**Consultation Response from KC,  
Highways Development Management**

**2023/91251 adj, 18, Wells Road, Thornhill, Dewsbury, WF12 0LE**

**Discharge conditions 6 (parking), 7 (retaining walls/ structures), 8 (wastes), 9 (bat box) 10 (evc), 11 (Phase I Desk Study Report), 17 (drainage) on previous permission 2021/90209 for erection of detached dwelling**

**Date Responded: 20/06/23**

PHASE	SCALE	SHEET NO.	PROJ.NO.
Building Control	1:200 @ A3	ST-10	E20054

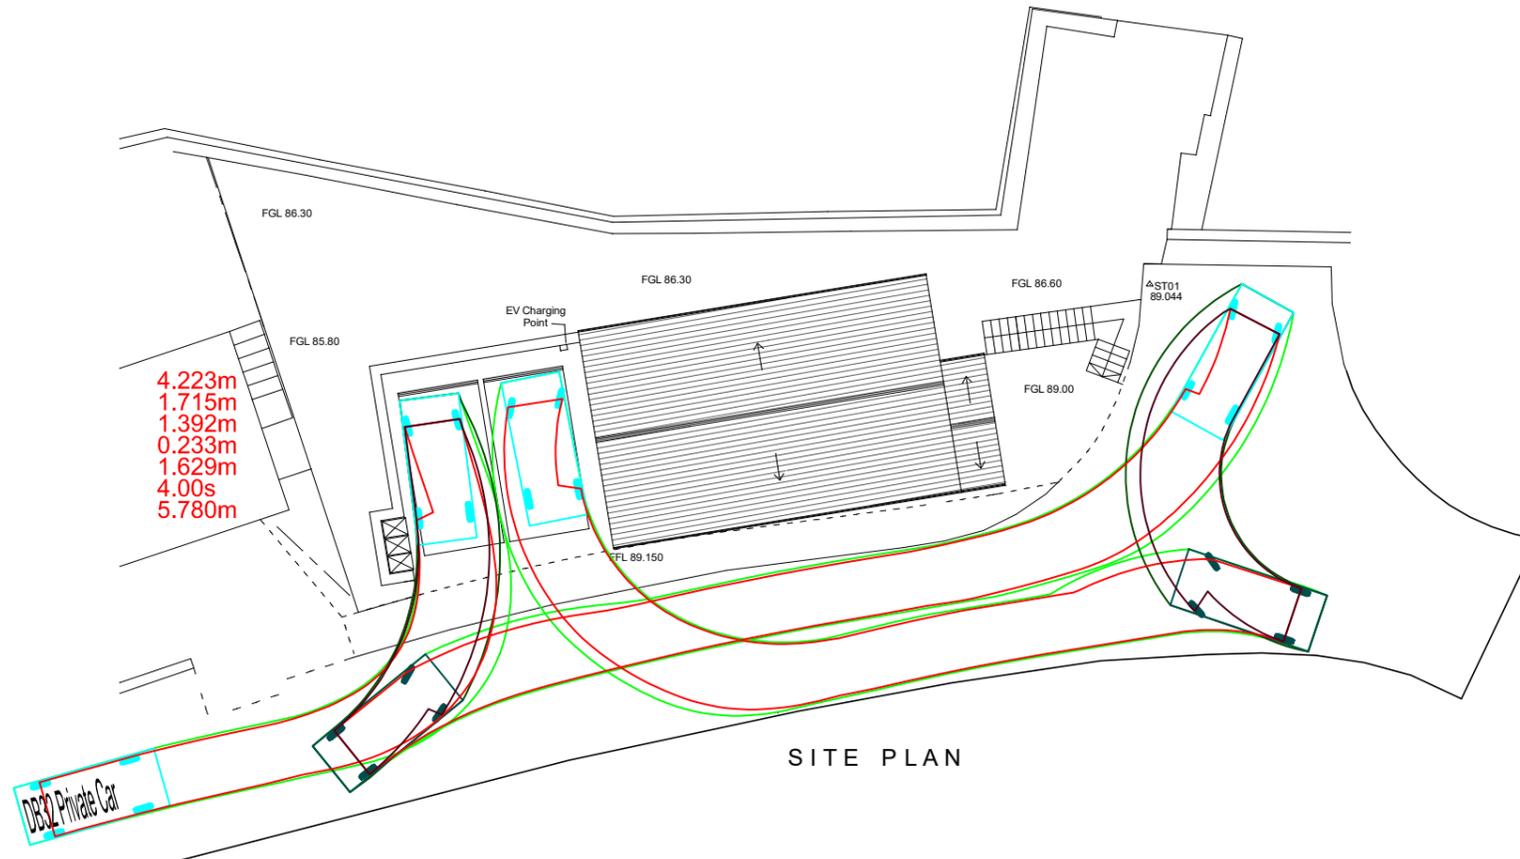
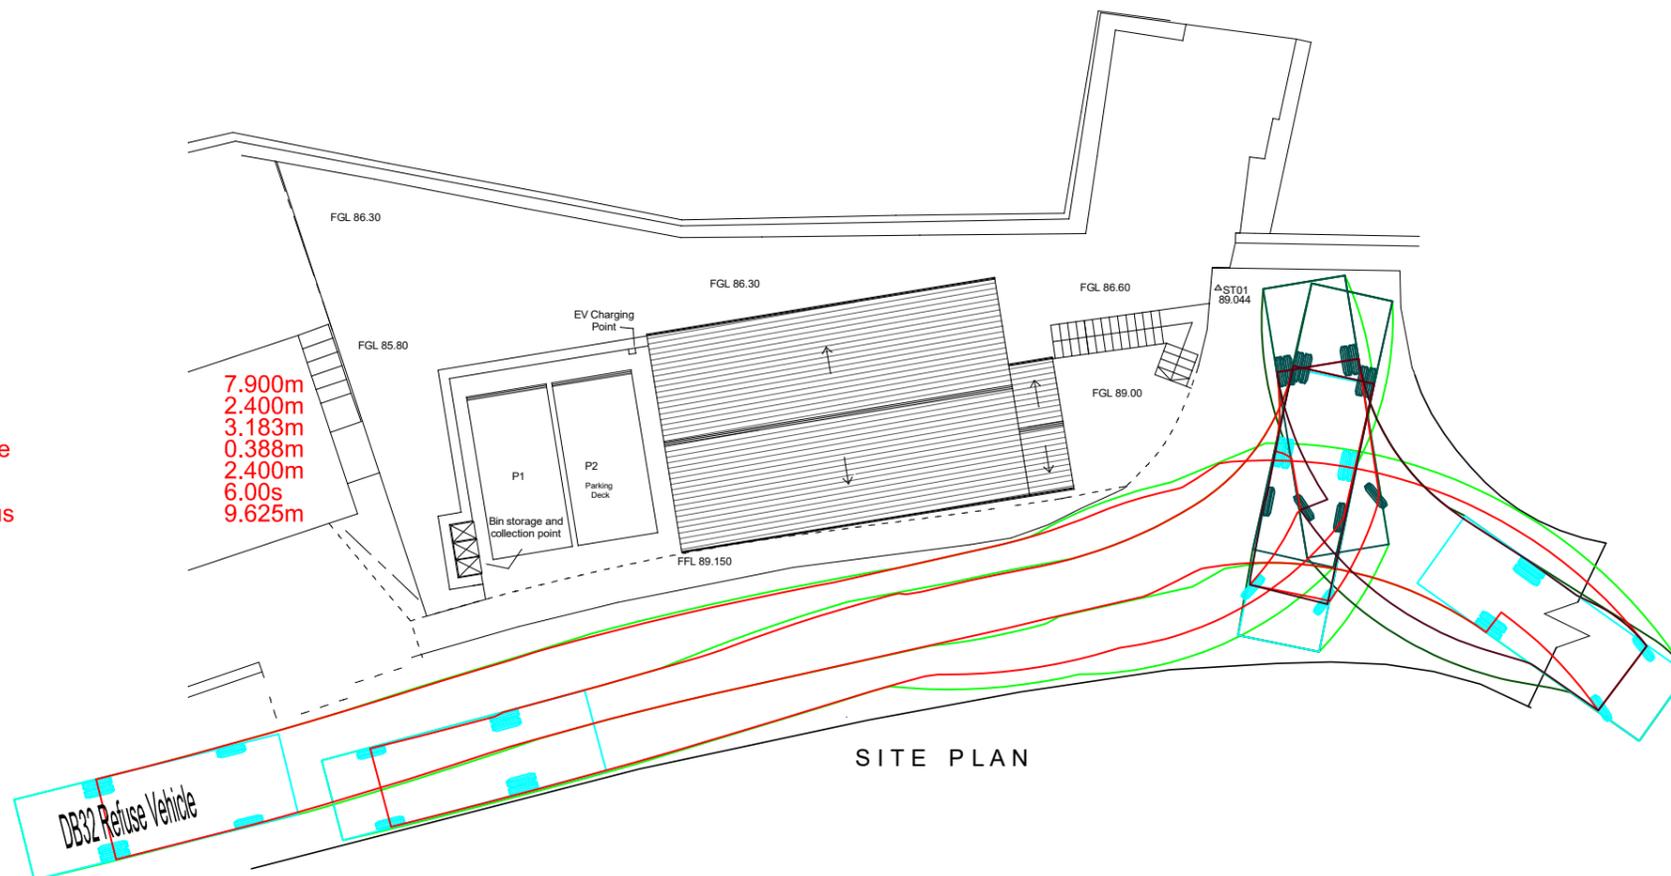
The information submitted in drawing No ST/10 Vehicle Tracking is acceptable for discharge of condition 8. The adjacent properties are serviced by a large RCV and so access for this has been shown to be available. The location of the waste bin storage/collection points is within guidance and is

acceptable.

Condition 8 – discharge of this condition acceptable.

DRAWING TITLE
Retaining Wall Design

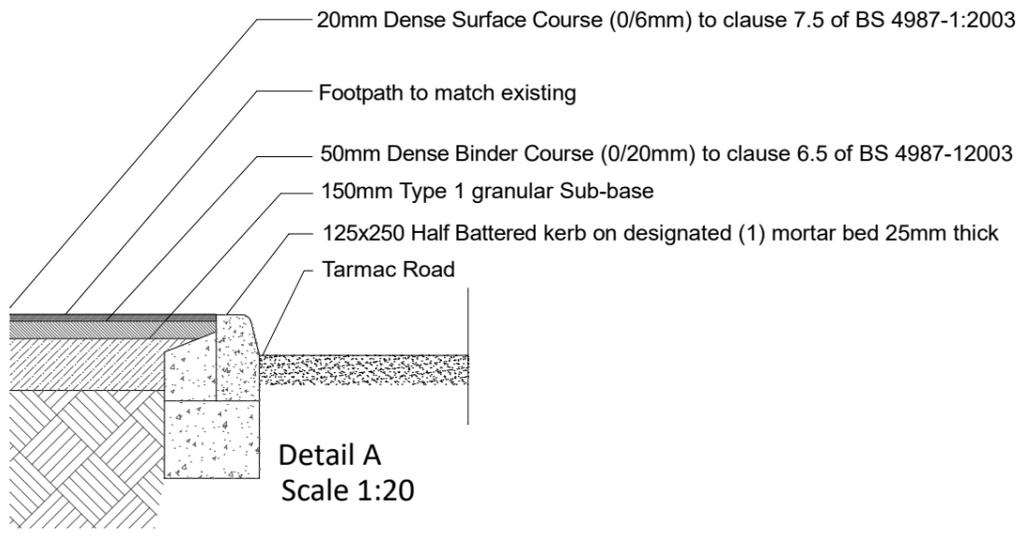
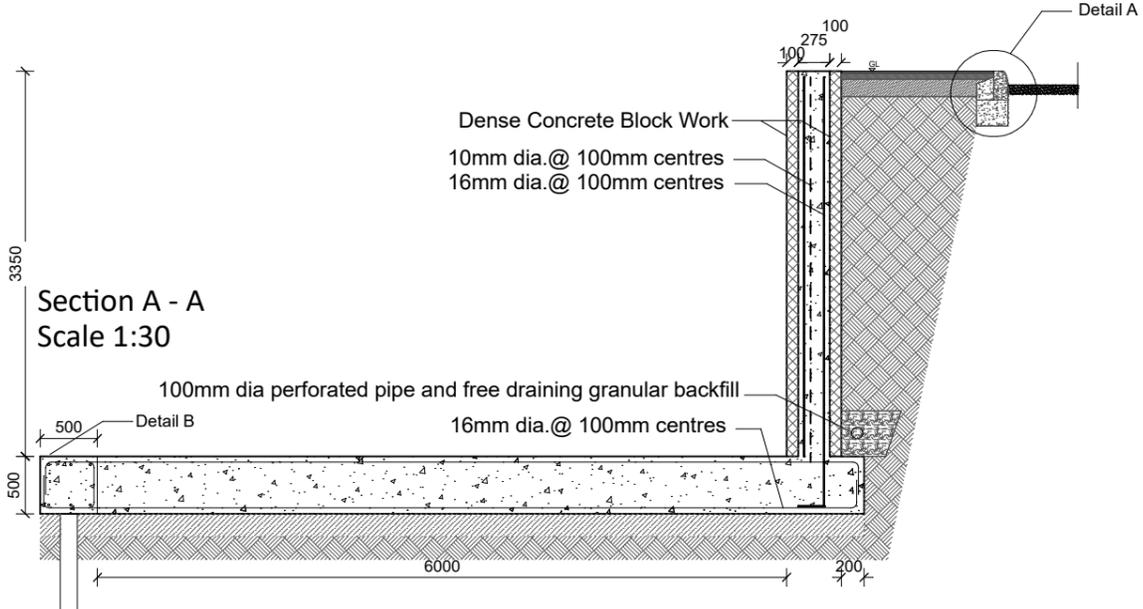
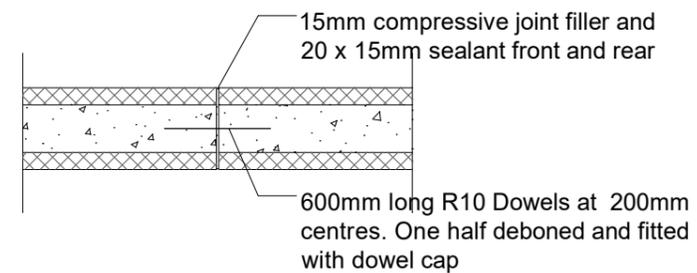
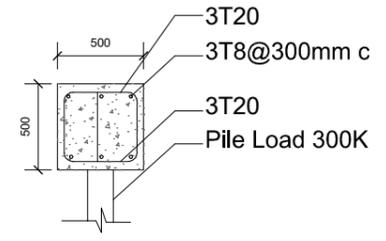
In consultation with the Kirklees highways structures team, we have been informed that the design of the burr wall supporting Wells Road would require a formal technical approval via submission of an AIP. Until the burr wall has been granted a technical approval, we would **not** be able to support discharge of condition 7.

Condition 7 – no discharge until an AIP for the structure has been submitted and Kirklees highway structures have granted a technical approval.
